SOUTH HOLLAND DISTRICT COUNCIL

Purpose: To consider Planning Application H16-0565-24

Description: Construction and operation of a micro energy storage facility

Location: Land On The North West Side Of Roman Bank Spalding

PLAN 2

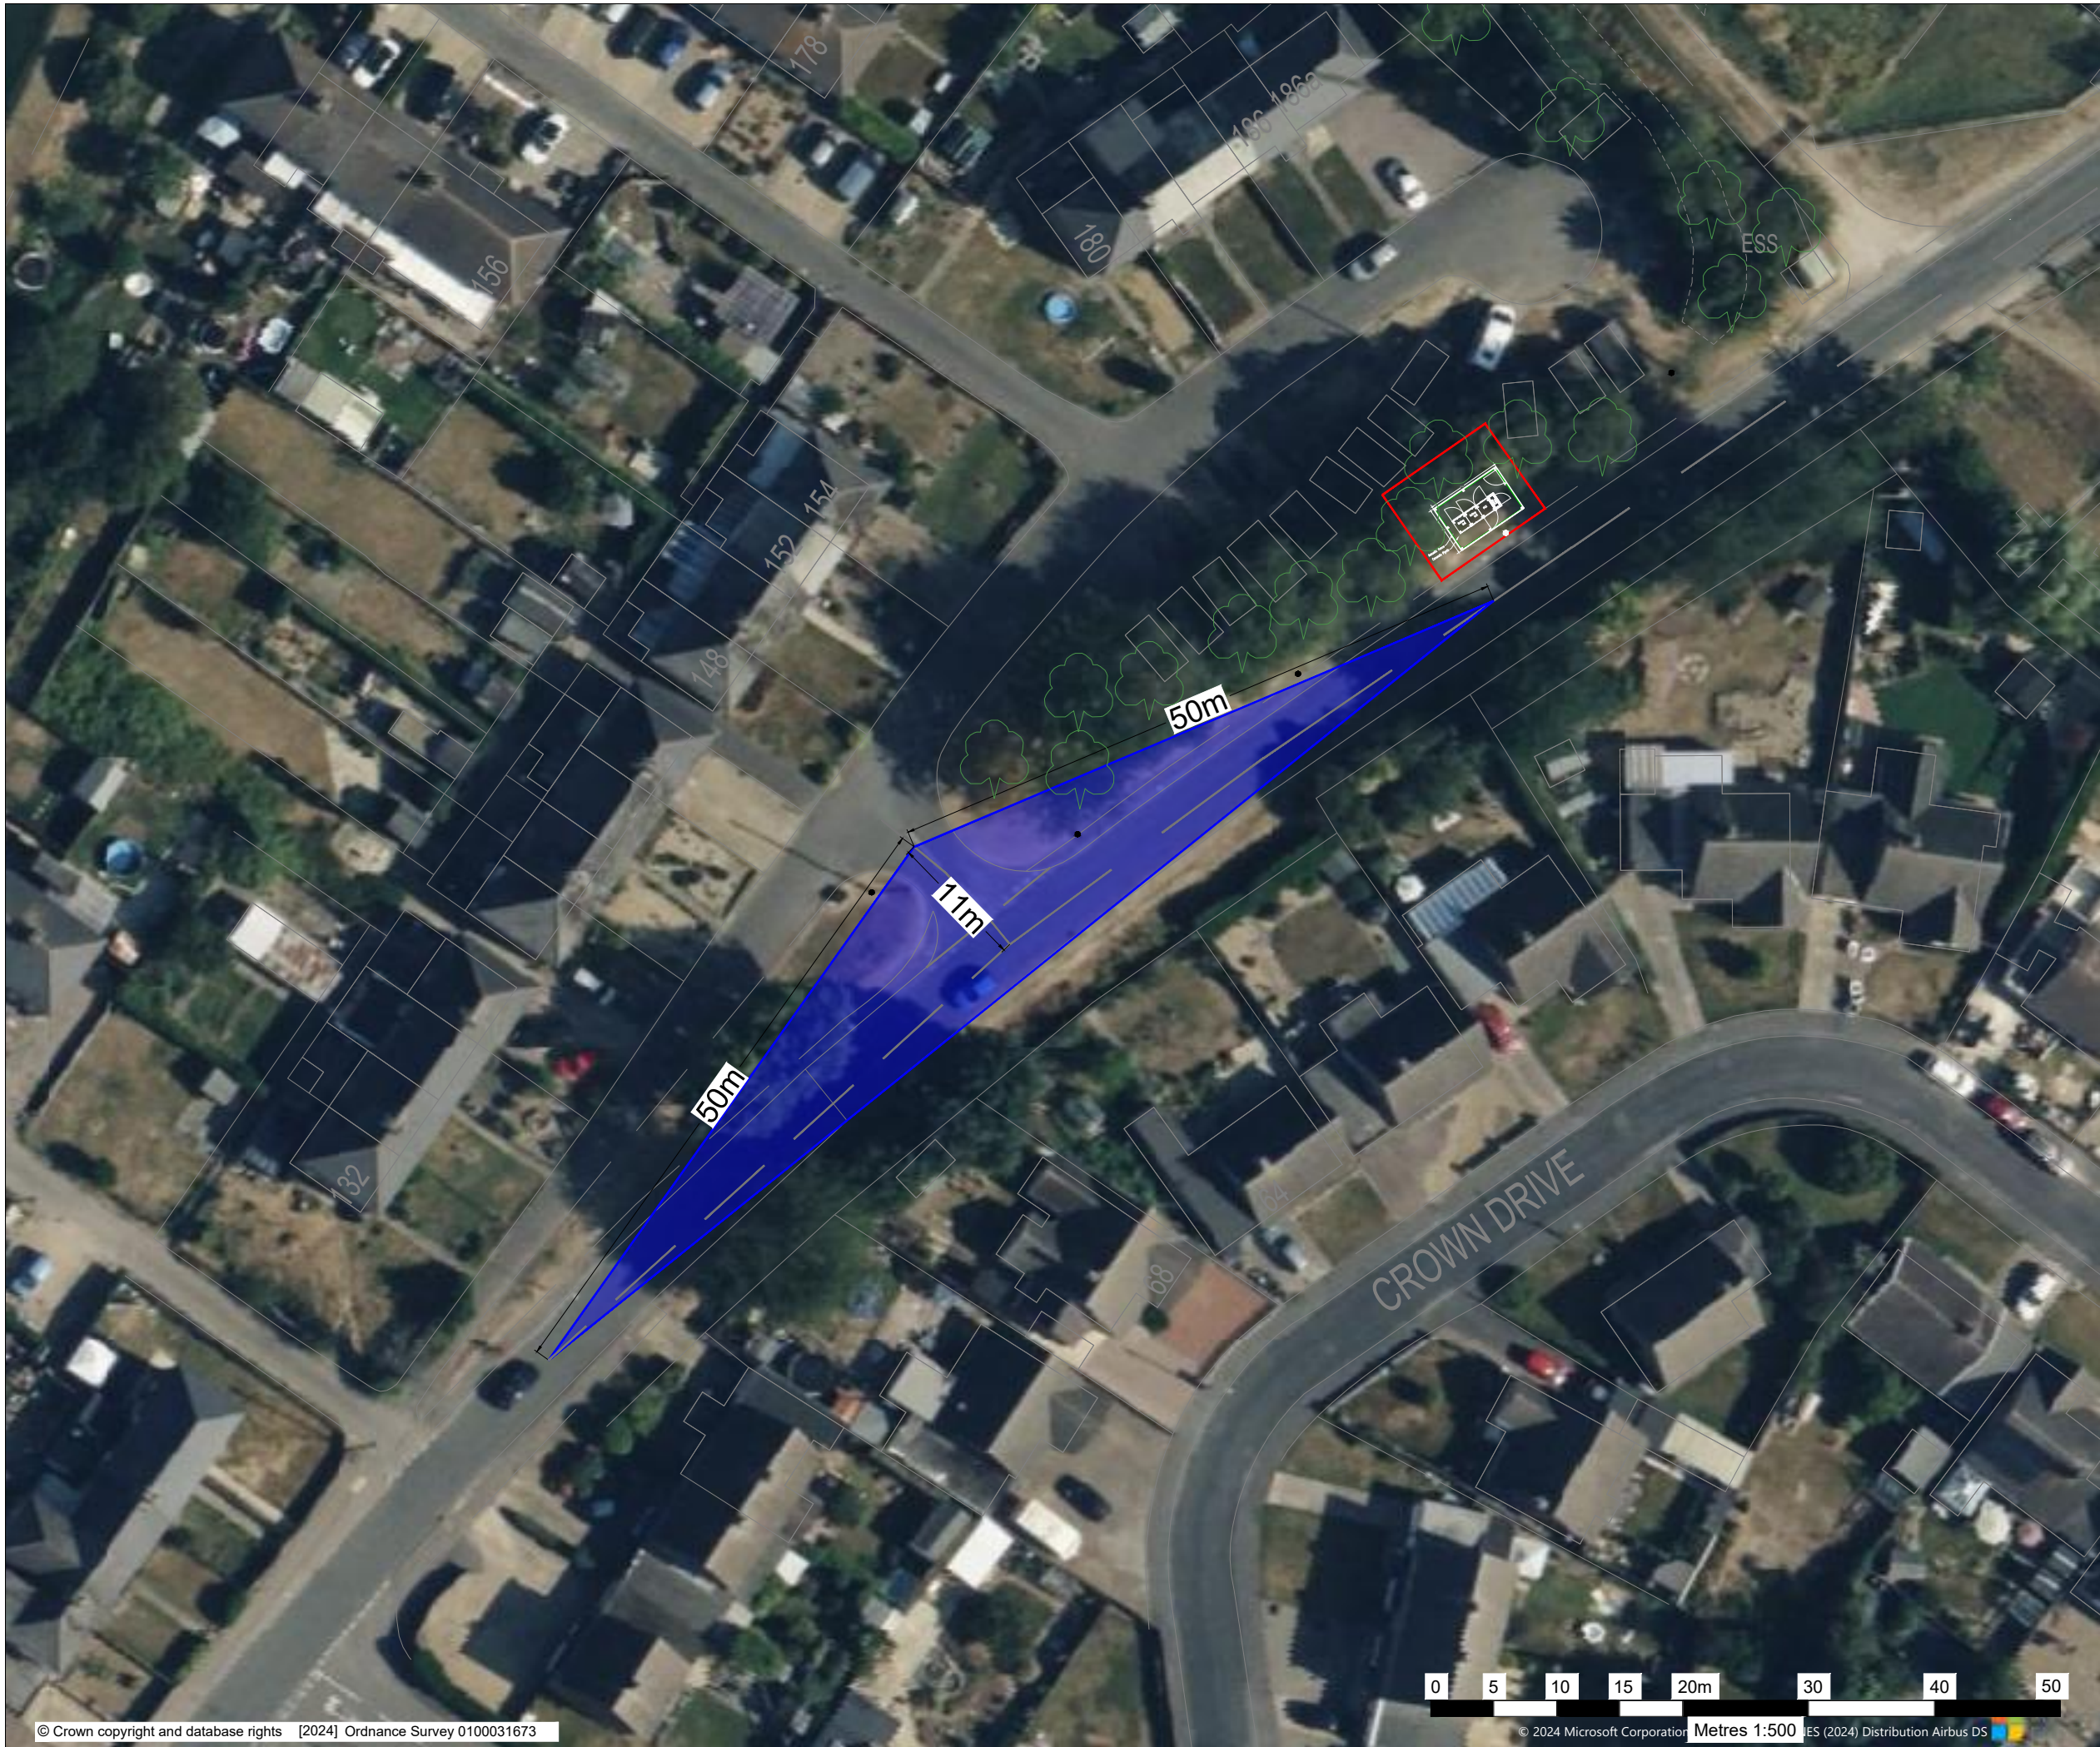
- 6.13 LCC Highway and Lead Local Flood Authority
- 6.14 Need to be sure that it will not obscure visibility for vehicles leaving Roman Bank - layout plan needs to show exact position of the equipment in relation to the extended site with visibility demonstrated in accordance with Manual for Streets from Roman Bank - plan should also include all existing street furniture.

location of the plant will not obscure visibility for vehicles leaving Roman Bank - visibility has been demonstrated satisfactorily. The frequency of construction vehicle movements is very low - 6 HGV movements and the construction period will be 4 weeks. Operational movements just if there is a fault or for maintenance. The proposal will not have an adverse impact on the public highway.

- 7.29 The proposal is for the construction and operation of a micro energy storage facility. The location of the plant will not obscure visibility for vehicles leaving Roman Bank, with the submitted visibility plans demonstrating adequate visibility. Construction takes approximately 4 weeks, manufactured away from site then lifted into position on a concrete plinth before electrical connection is made. Traffic generation during construction and operation will be minimal - 3 HGV arrivals and 3 departures. It is controlled remotely so any other visits will be if there is a fault - negligible movements. The proposal will not have an adverse impact on the public highway.
